From: simonstone [mailto:simonstonepc@talktalk.net]
Sent: 14 October 2012 16:59
To: Colin Sharpe
Subject: 0789 land opposite Foxhill Whins Lane

Please find below the Parish Council's objections to the above planning application

PROPOSED PLANS & ELEVATIONS

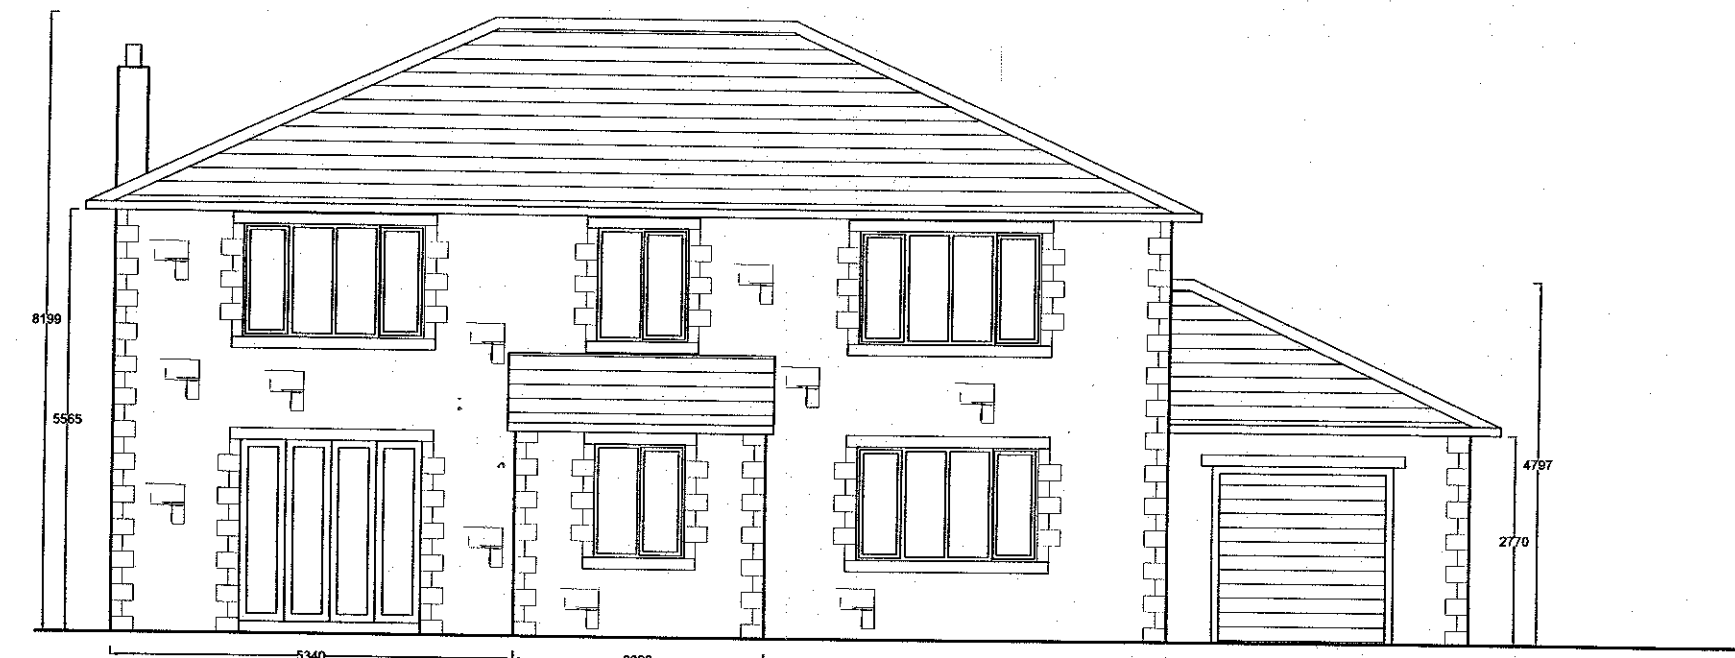
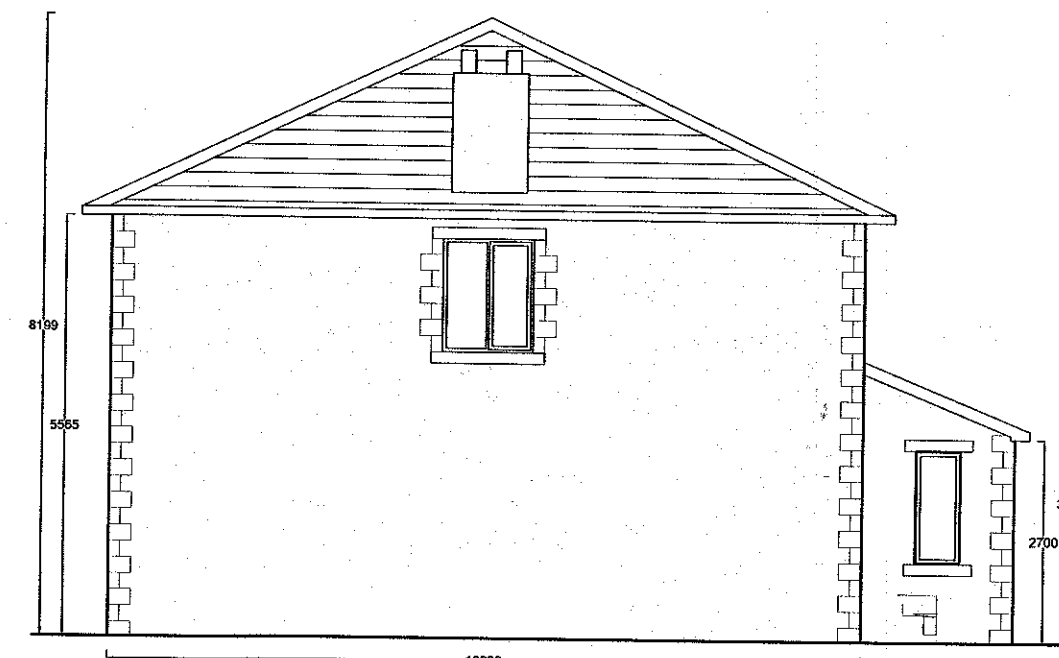
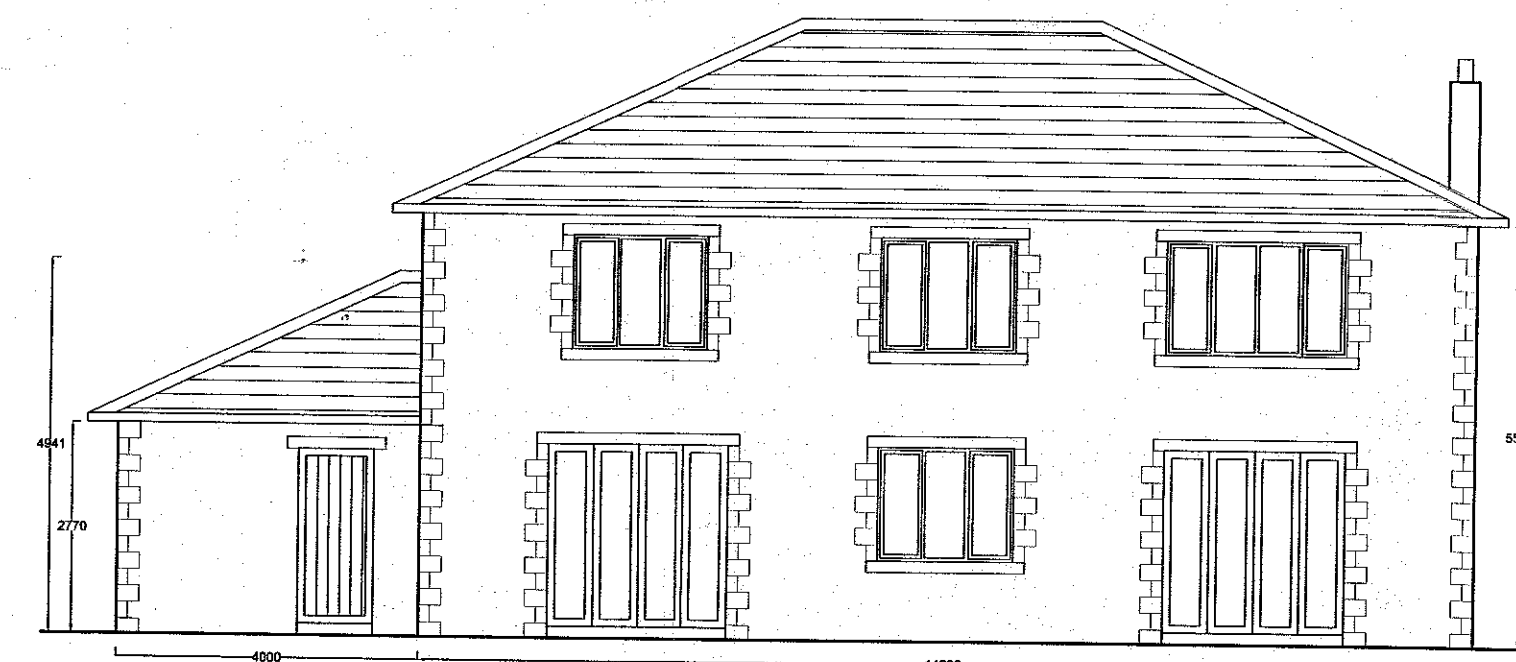
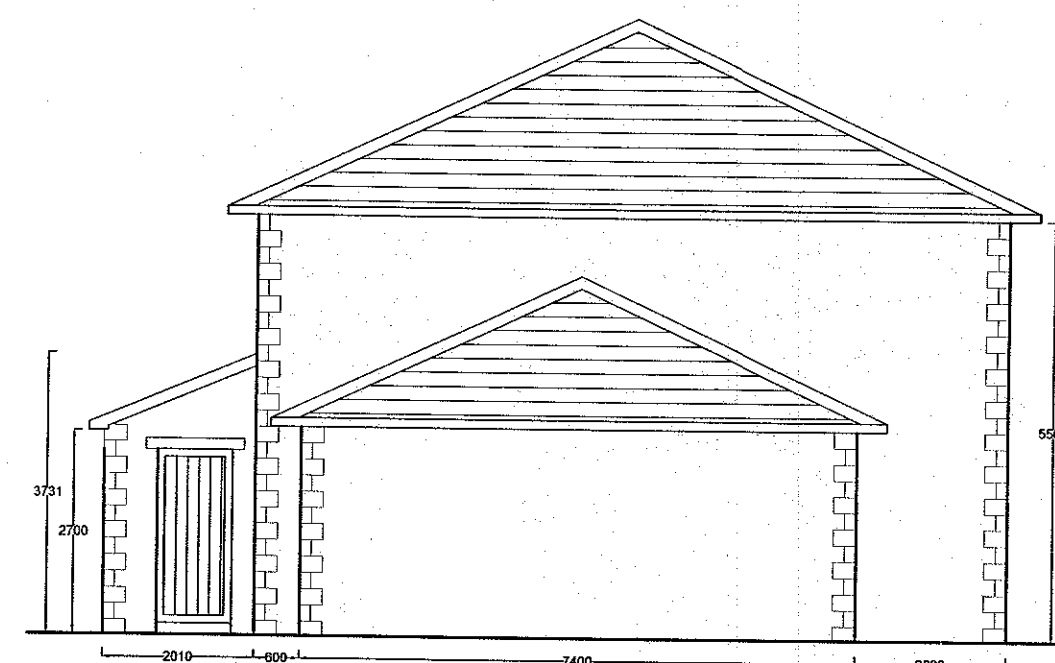
- 1) The development is outside the settlement boundary, and therefore doesn't meet the criteria set out for development.
- 2) The height of the house does not fit in with the surrounding properties, and is out of character.

- 5) I do struggle to see how the property is going to fit on the site. Hence that is why the height of the house has been increased. It will make it one of the tallest houses in the area.
